Case Officer: Bob Neville

Recommendation: Refusal

Applicant: Mr & Mrs Broom

Proposal: Conversion of existing stone/brick barns to 1 no dwelling and conversion of existing steel pole barn to 1 no dwelling. Associated works including landscaping and new access

**02** Main Street Elevation As Proposed  
1:200

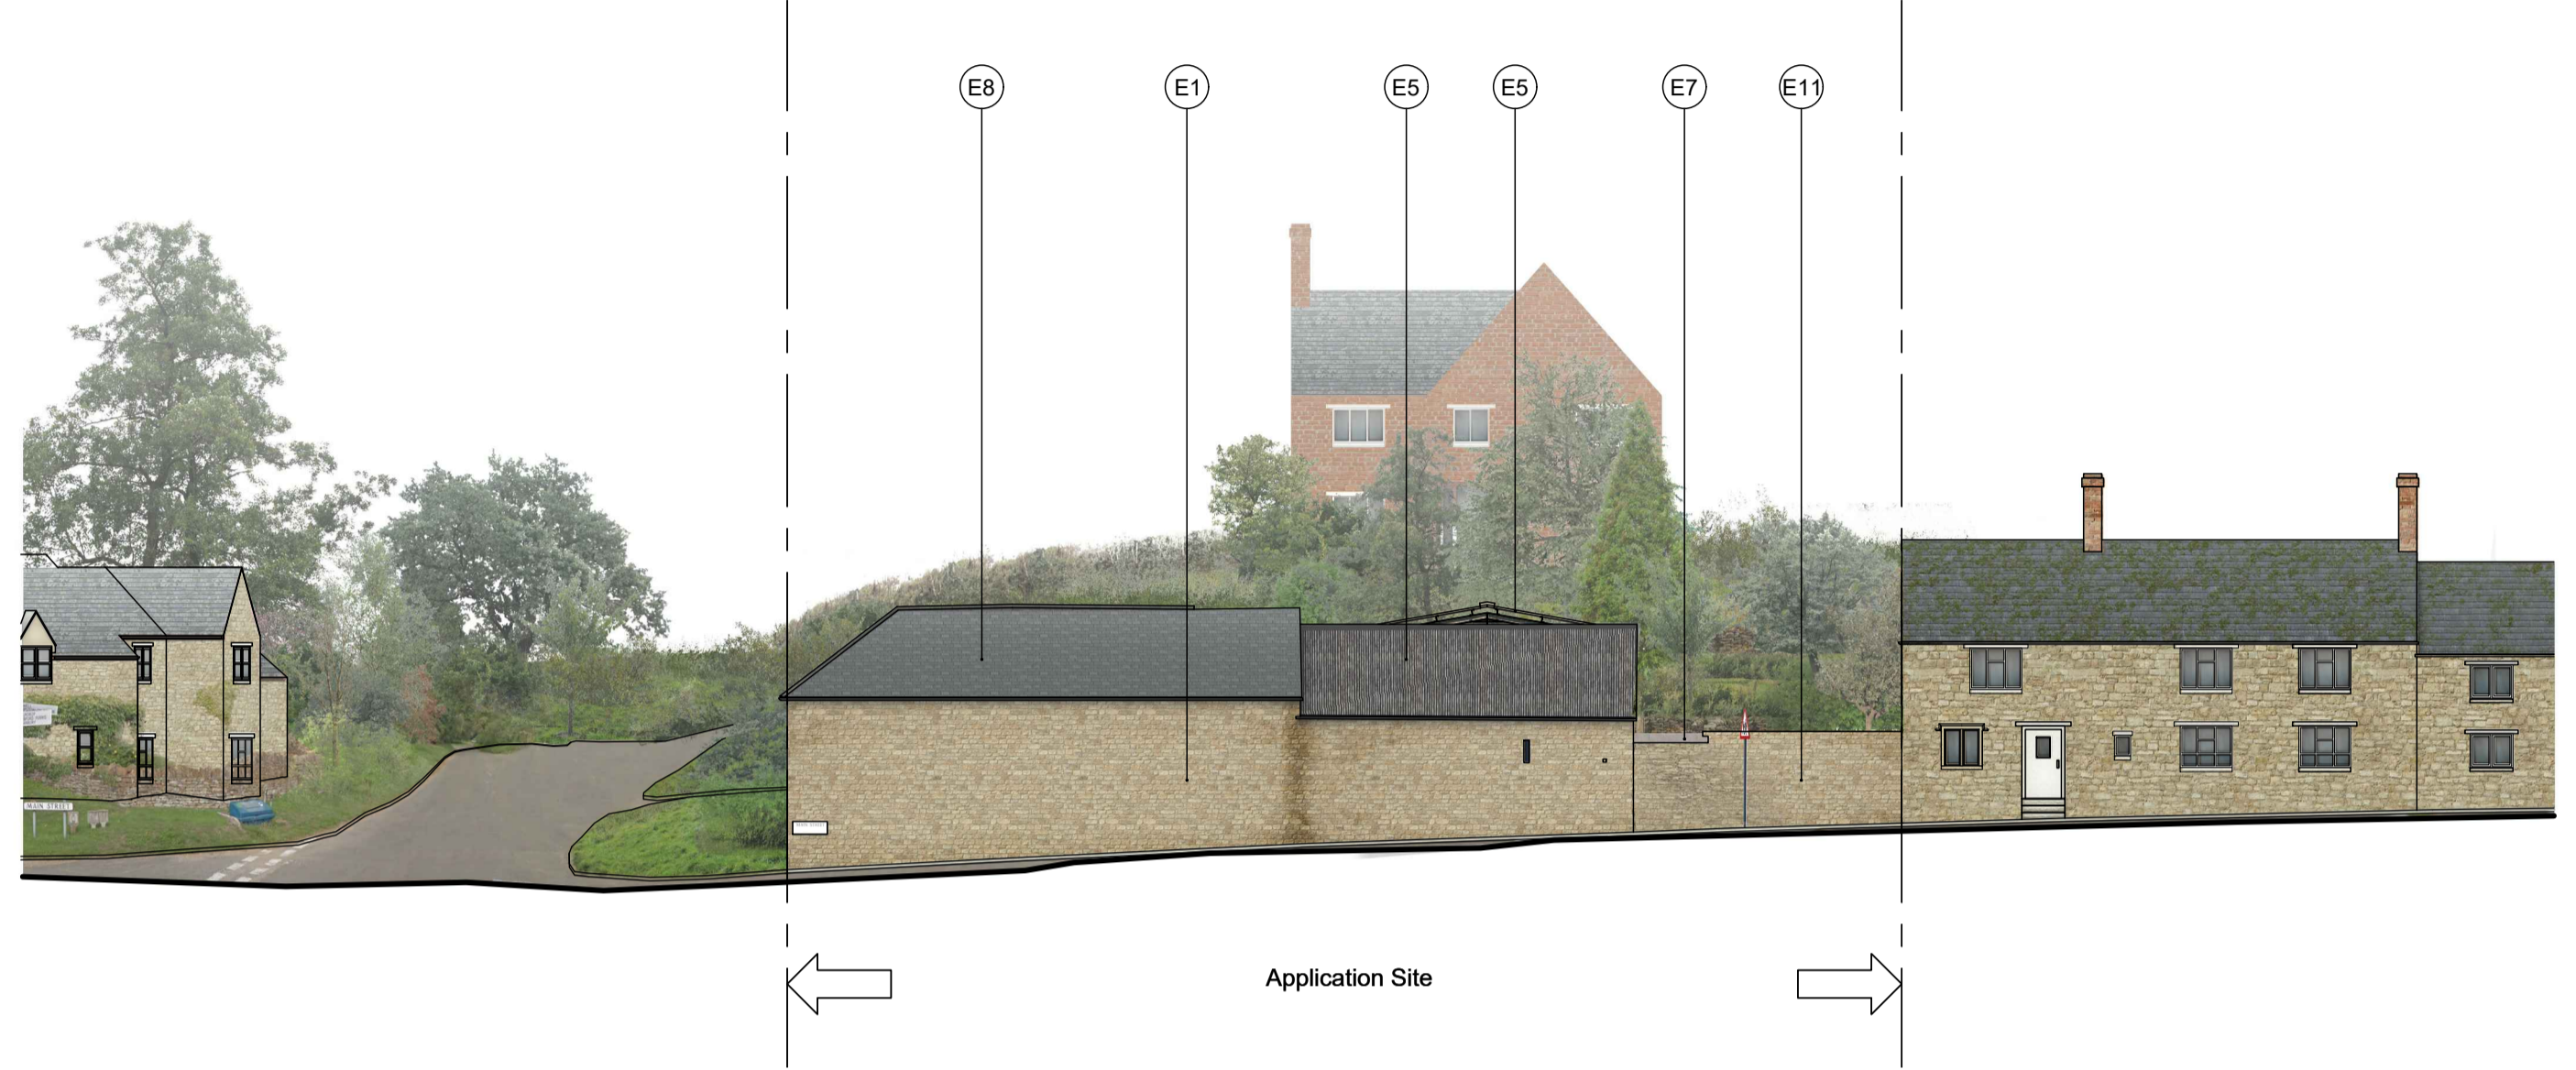
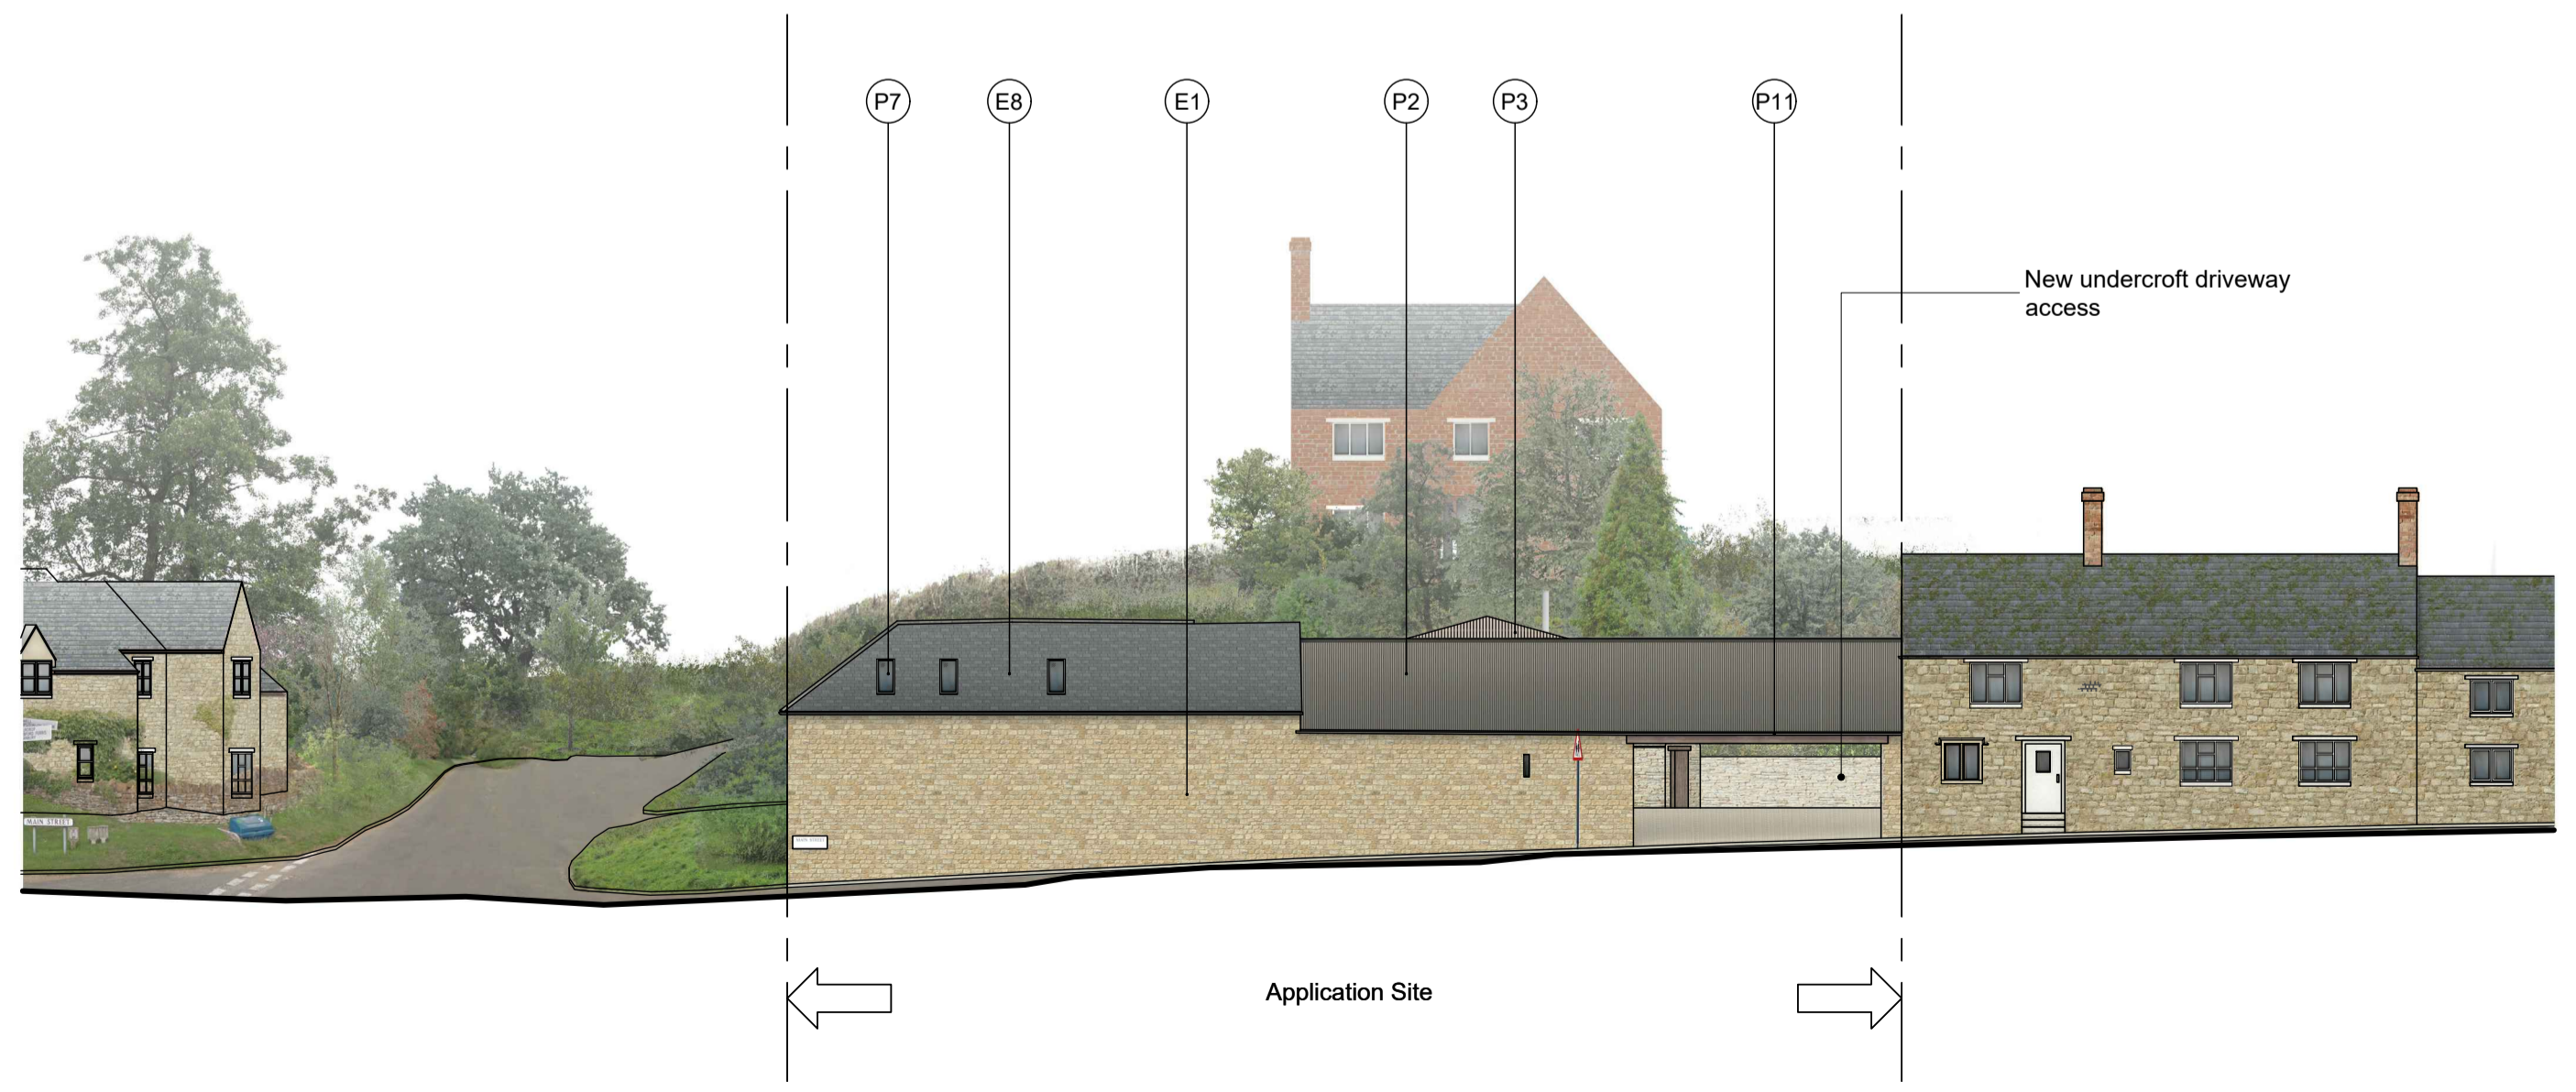
- 8.19. The proposals include the removal of approximately an 8m section of the ~2.7m high boundary wall along Main Street. Whilst it appears that the wall did not originally form part of the adjacent barn, it is a historic feature which has formed part of the character of the street-scene in this location, and along with properties to the north gives a strong sense of enclosure along Main Street. The removal of this section of wall would cause significant and demonstrable harm to the character of the street-scene, affecting not only the character of the site, but also the wider setting of this part of the Conservation Area and the setting of adjacent grade II listed buildings.

- 8.20. Saved Policy C23 states *'that there will be a presumption in favour of retaining buildings, walls, trees or other features which make a positive contribution to the character or appearance of a conservation area'*. As demonstrated in the late submission of revised plans there is an alternative solution for a new access to serve the development that would not require the loss of the section of boundary wall along Main Street and as such in officers consider the loss of the wall is not justified given the impact that it would have on the character and appearance of the site and wider setting.
